## Appeal Decision

**Decision date: 21 April 2016**

**Appeal Ref: APP/C3105/Y/15/3138337**

**Chancel Cottage, Fir Lane, Steeple Aston, Bicester OX25 4SF**

Fig.29 - Proposed First Floor Plan

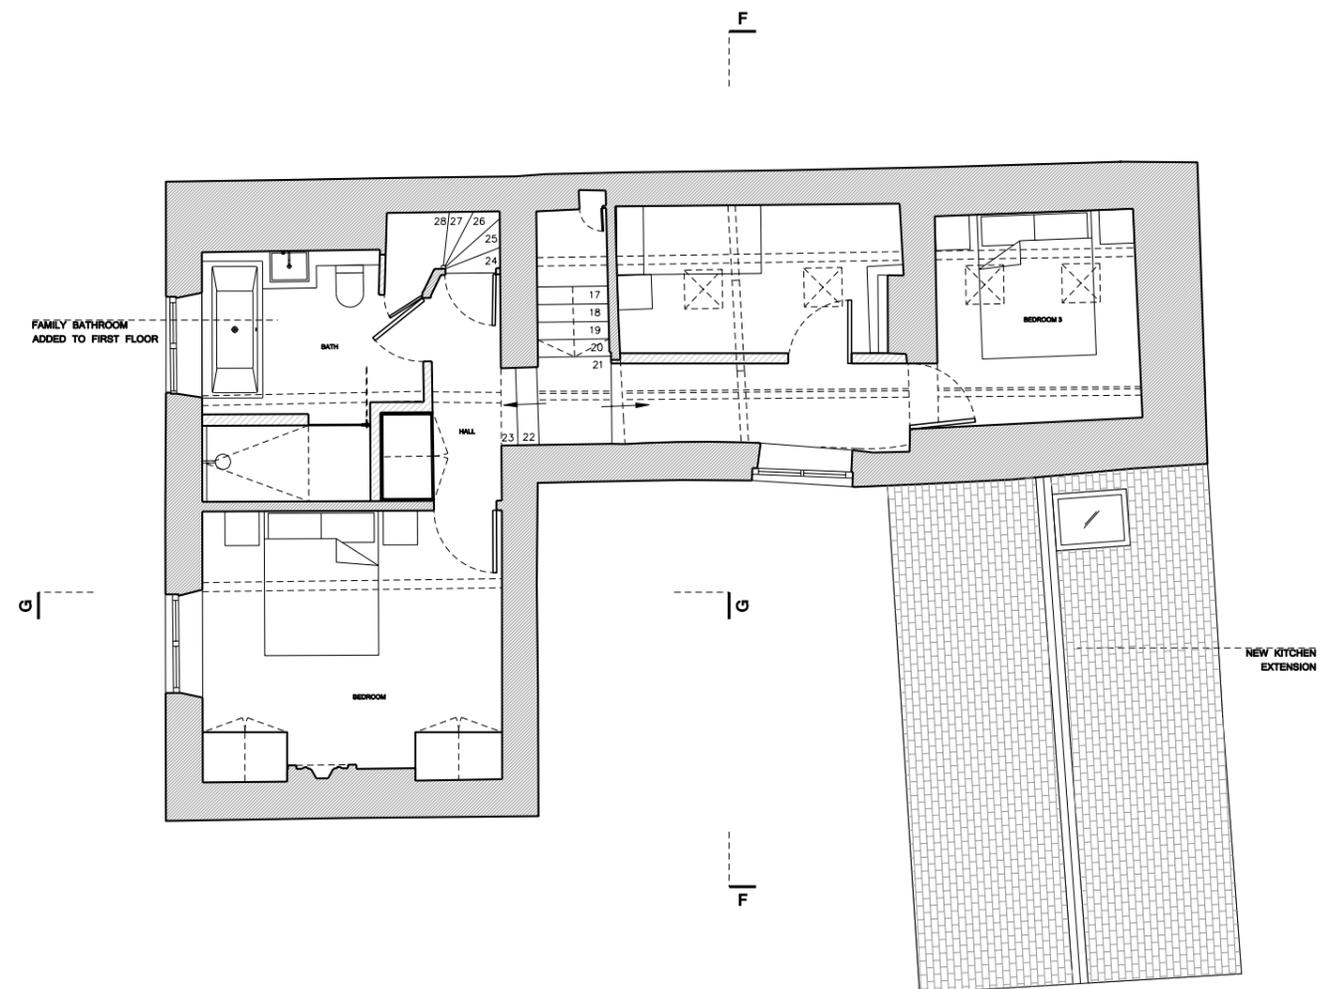
18. Internally the provision of a doorway at first floor level breaking through from the rear extension to the former stable would result in the loss of historic fabric and create a connection between parts of the building that was not formerly there. This would reduce the physical and occupational division of the building parts and reduce the historical distinction between those parts of the building that were originally accommodation and those that were not. To this extent this element of the works would harm the significance of the listed building. The appellant suggests that, even if this is accepted, the use of the upper floor of the former stable would enhance its protection and create a sustainable use for it such that would afford it greater protection and maintenance therefore safeguarding it better for future generations. The Council appear to accept this proposition, and noted at the hearing and in their appeal statement that taken by itself the benefits of this element of the works would outweigh any harm that may arise. Whilst I would see there may be an argument in that direction I must consider all the aspects that lead to harm and assess that against the benefits and I shall turn to this further below.

Chancel Cottage - Proposed West Elevation

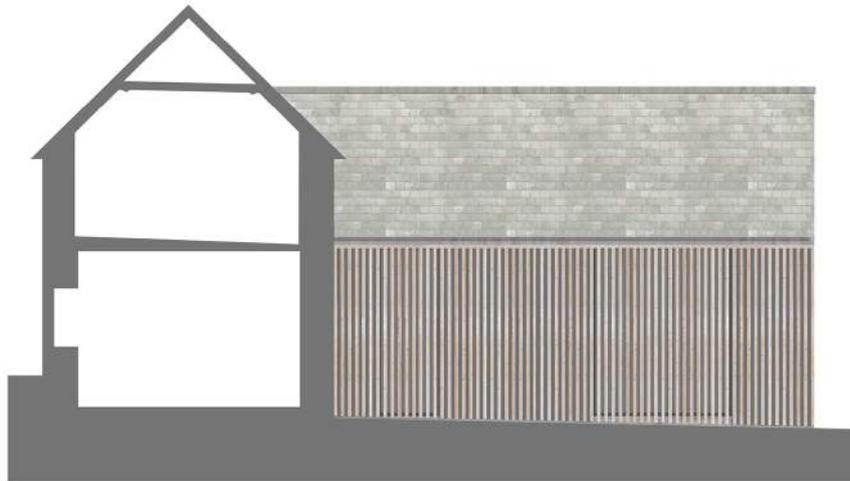
15. The use of a wooden slat facing on the west facing wall of the extension to differentiate the modern addition from the original building would in my view also create confusion. The appellant contends that such material is used in outbuildings and other structures in the area and therefore was a reflection of the surroundings. But if the intention is to differentiate new from old a very modern approach would be more successful than seeking to suggest this was an outbuilding attached to the main building. As this would potentially obscure the intent and form of the building.
